Recommendation Report for Prior Notification of Work to Tree(s) in a Conservation Area

REF NO: **AW/204/15/TC**

LOCATION: Tingewick
 27 The Drive
 Aldwick

PROPOSAL: Fell 1 No. Silver Birch tree & 1 No. Pittosporum tree within the Craigweil House
 Conservation Area.

TREE LAYOUT AT 27 THE DRIVE ALDWICK, PO21 4DU

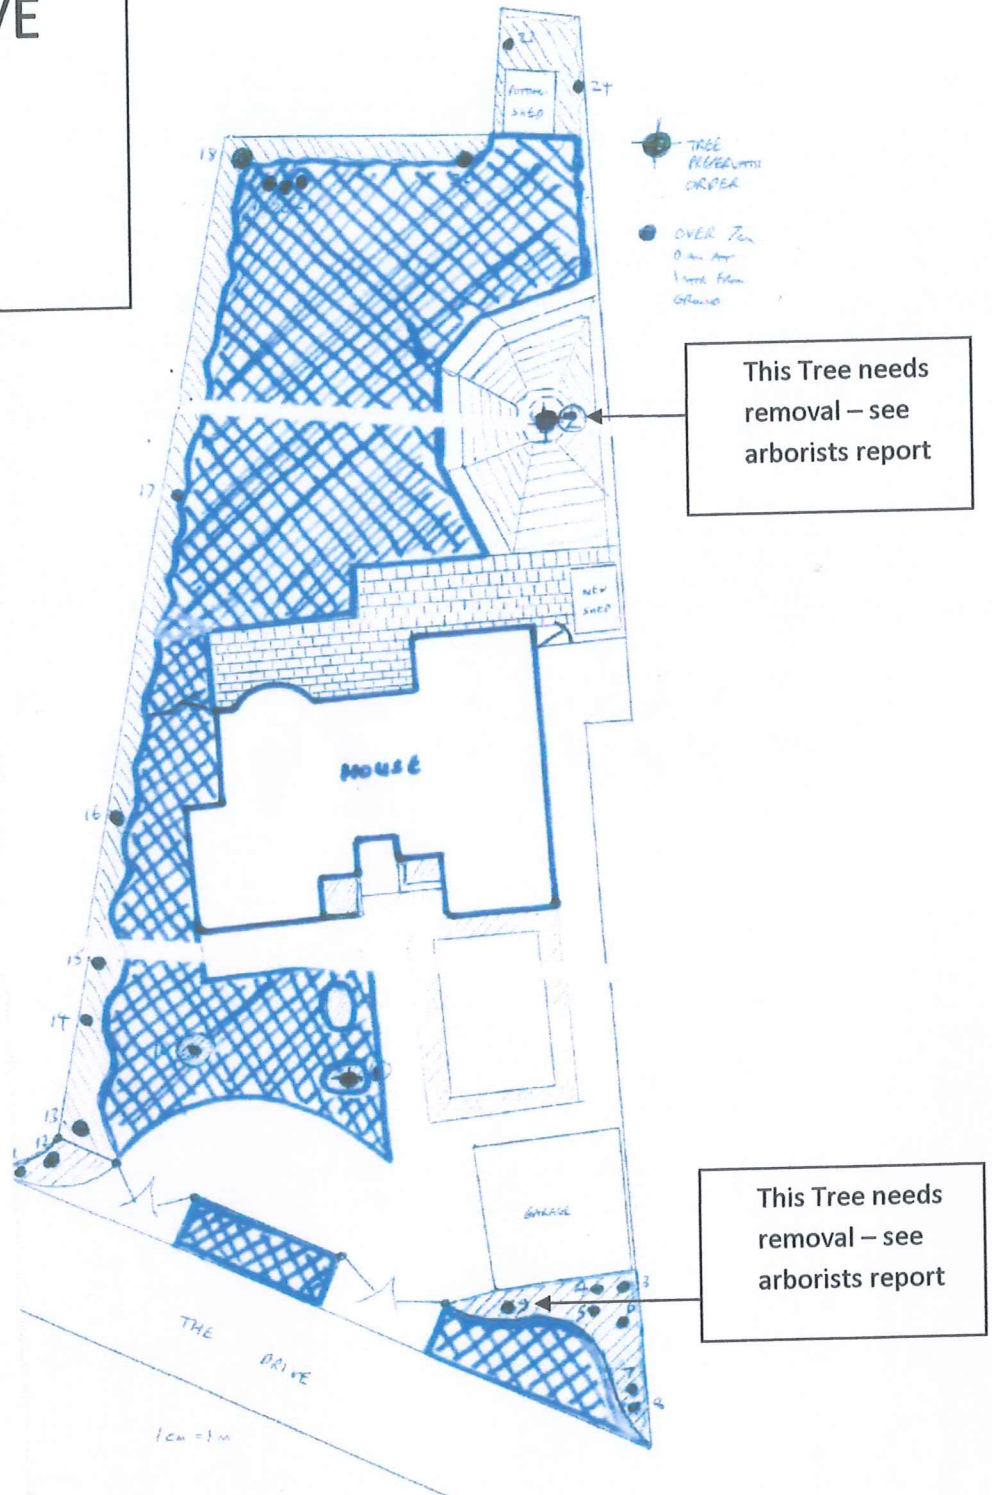
·The trees cited in this application are standing in the front and rear gardens of 27 The Drive. T1 is easily visible from the highway outside; T2 is not visible from the highway outside.

·From the site inspection it is clear that T1 and T2 are dead standing specimens. They are therefore not suitable for TPO orders.

·As both T1 and T2 do not have the attributes to warrant TPO orders, I would have no objection to the felling of both specimens.
